Planning Application AW/210/18/HH
Front Porch, Entrance Gate & Piers
1 Raycroft Close, Bognor Regis

PROPOSED PORCH AND ENTRANCE GATE
1 RAYCROFT CLOSE BOGNOR REGIS

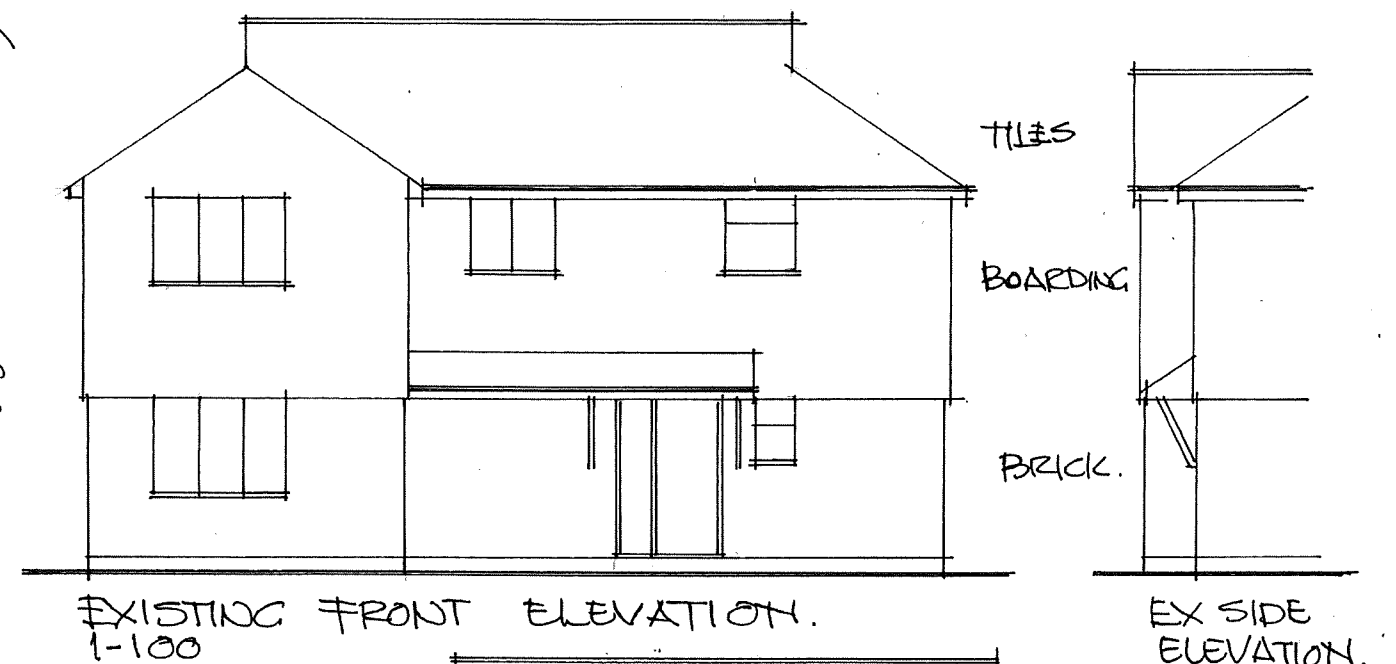
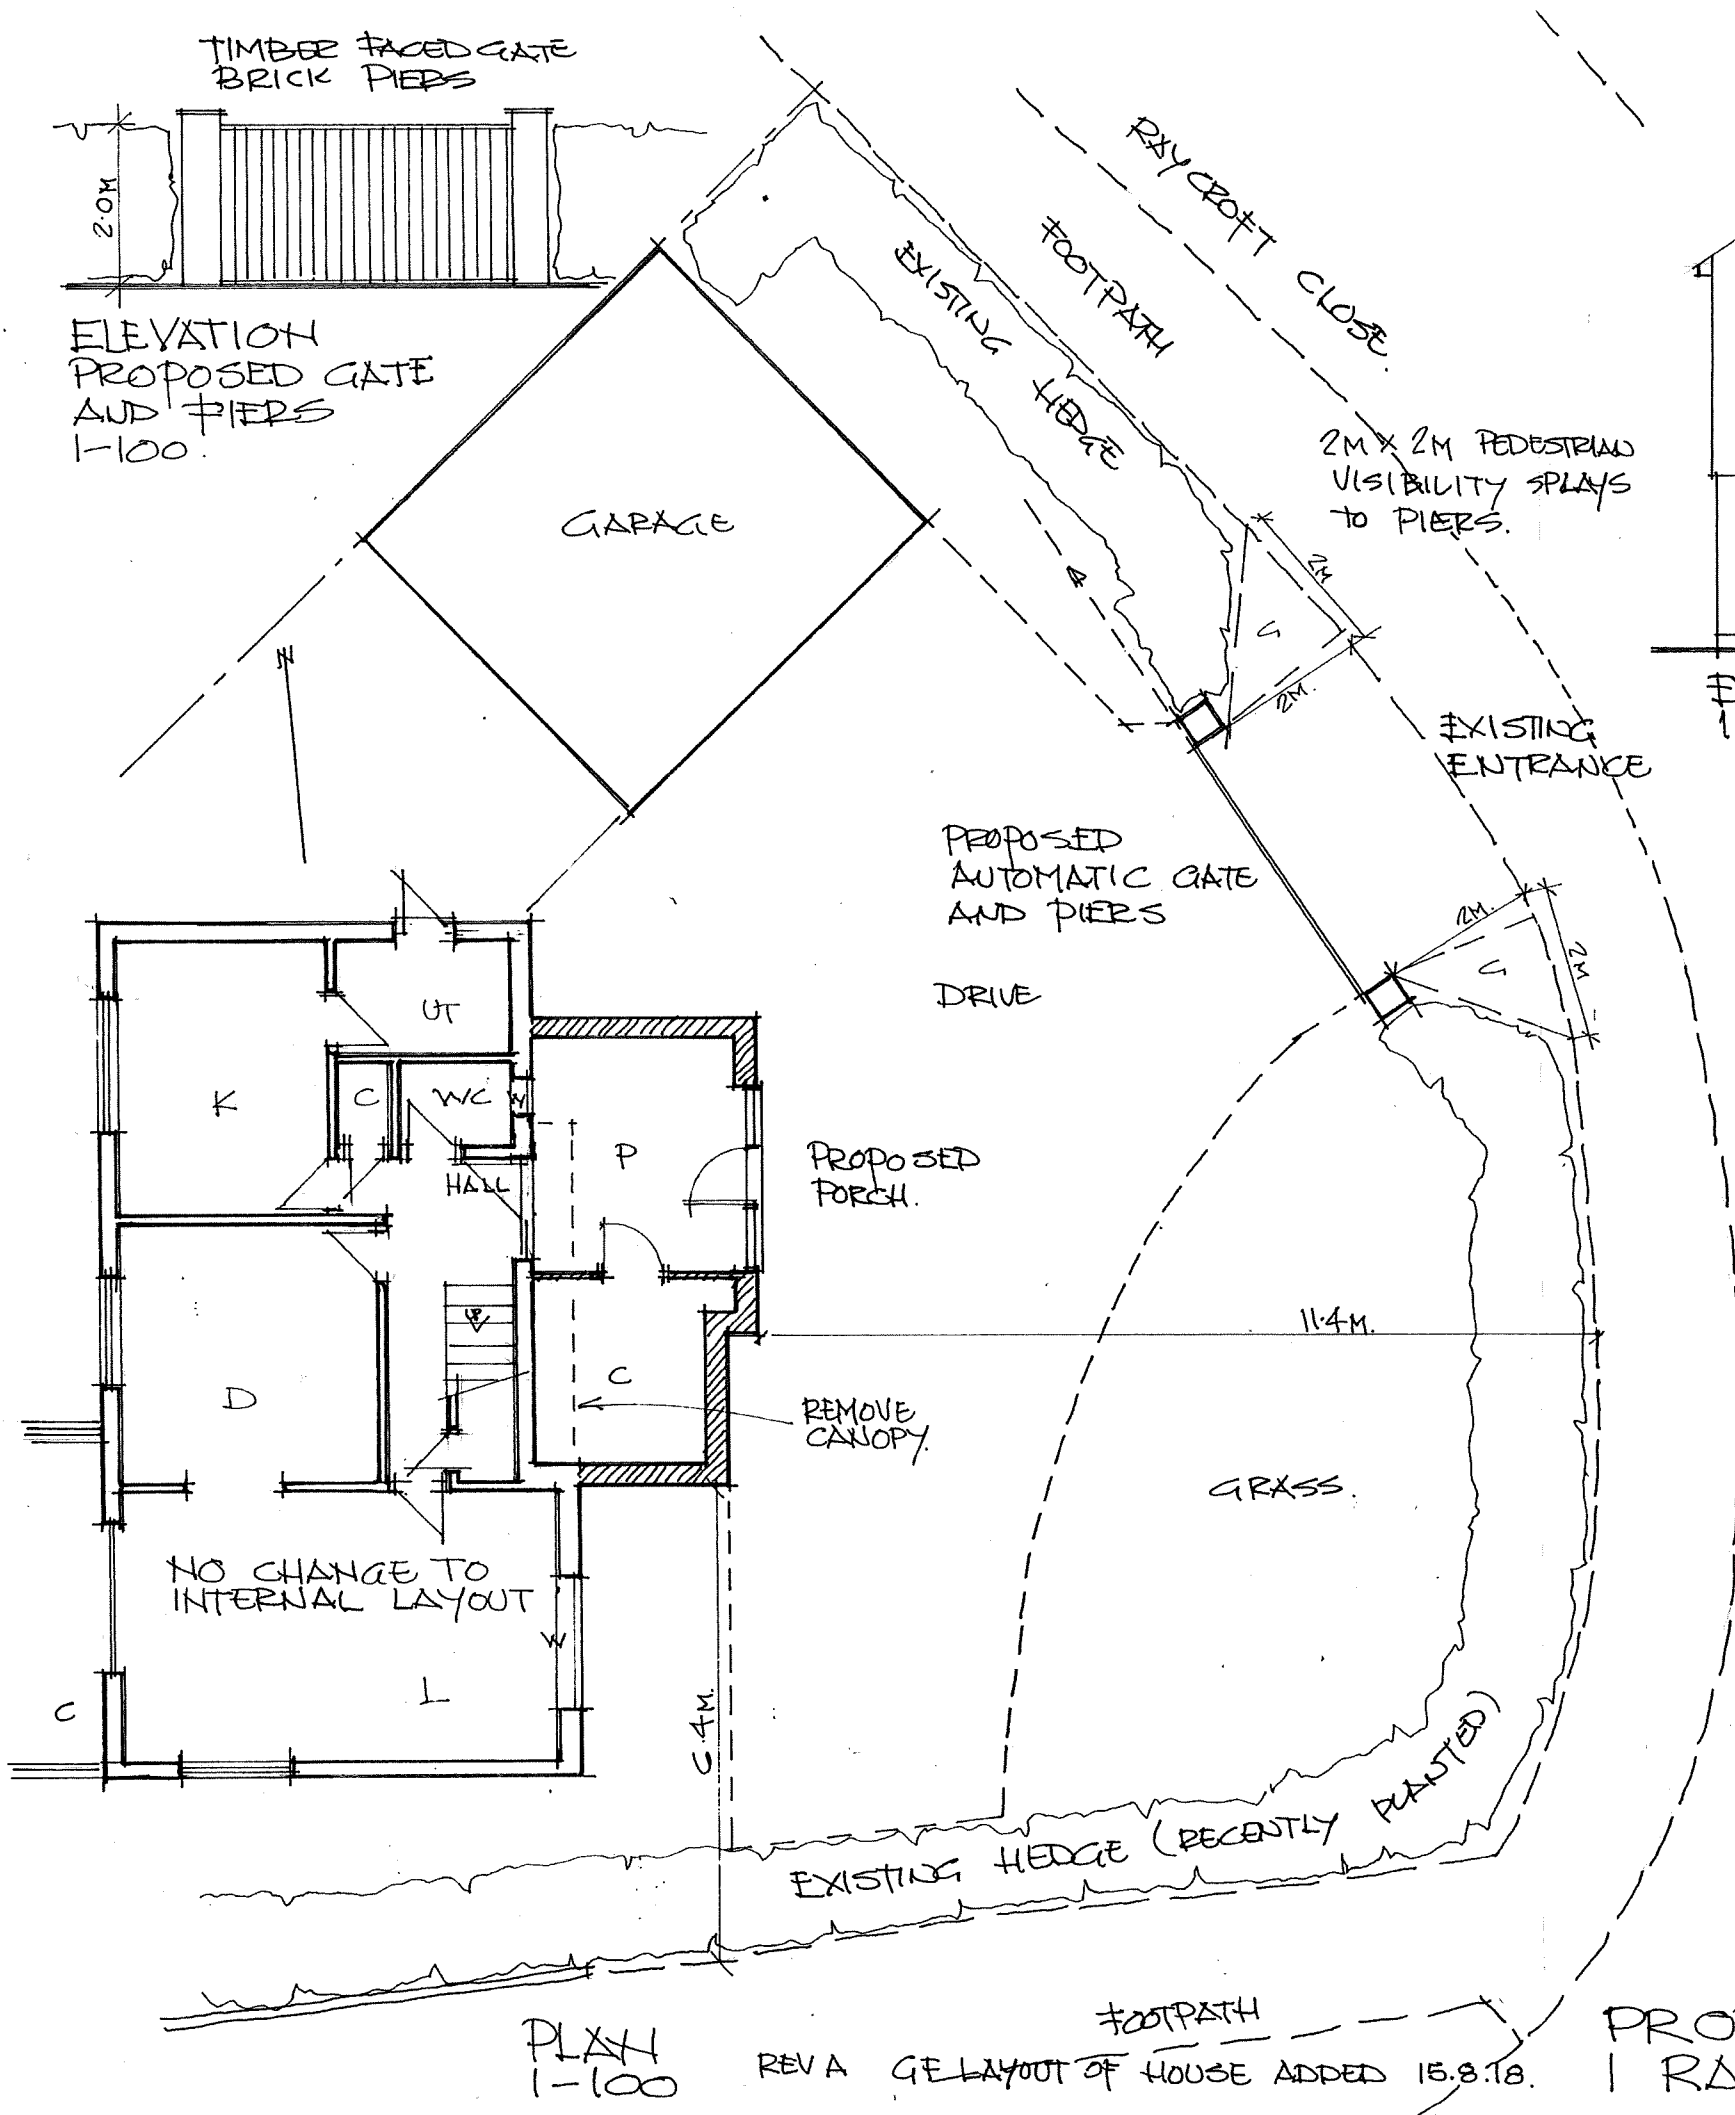
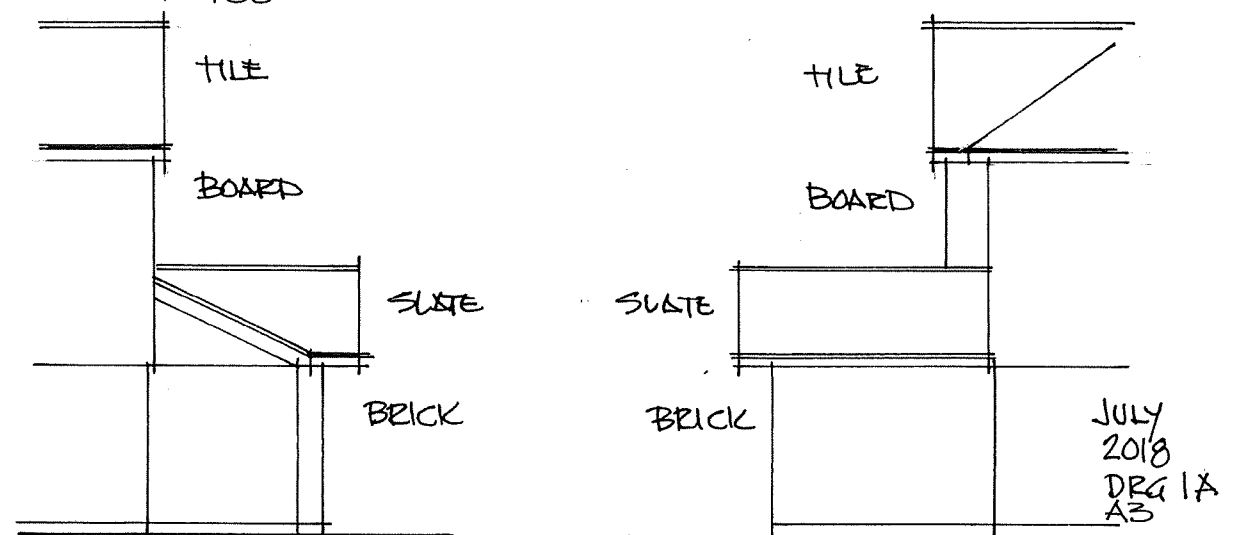
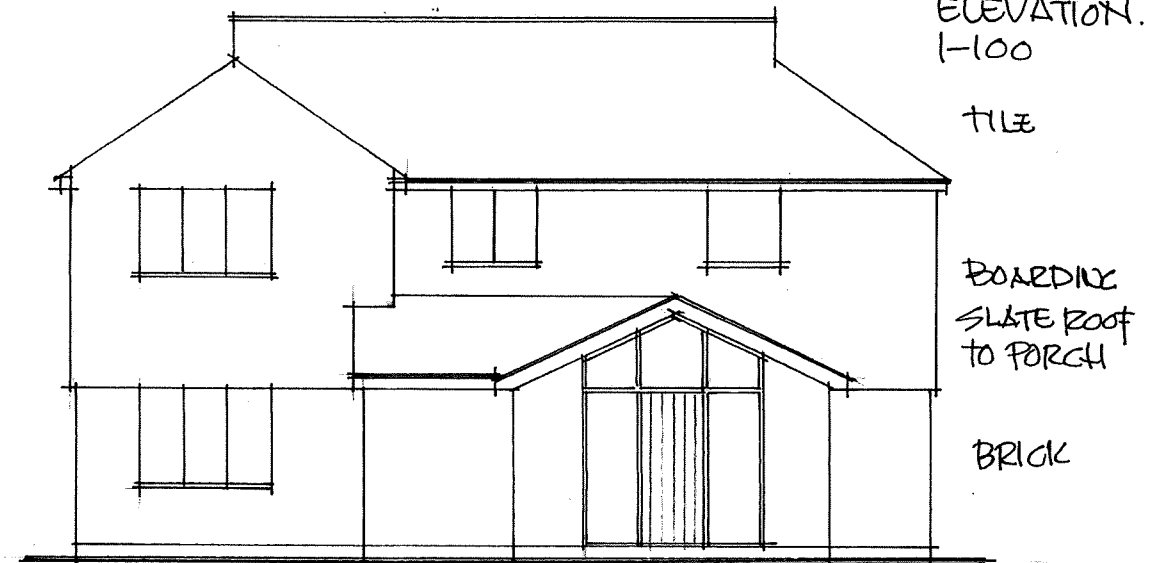
In response to the above planning application I have no objection to the construction of a porch on the named property, indeed it appears from the plans to be quite an attractive addition to such a prominently positioned house. I do however have the strongest objections to the construction of entrance piers and the fitting of electric gates with an overall height of 6ft 6ins.

With the proposed seven foot hedge (as yet non existent) and six foot six inch electric gate and posts, this house, which is in a prominent position will have the appearance of an embassy compound.

Such a construction goes completely against the architectural and landscaping concepts which underlay the estates original designs and which have been, almost without exception maintained to this day. To agree to the construction of such a dominant feature, of such height and so out of character with it's surrounds would set a dangerous and regrettable precedent for future ad hock developments.
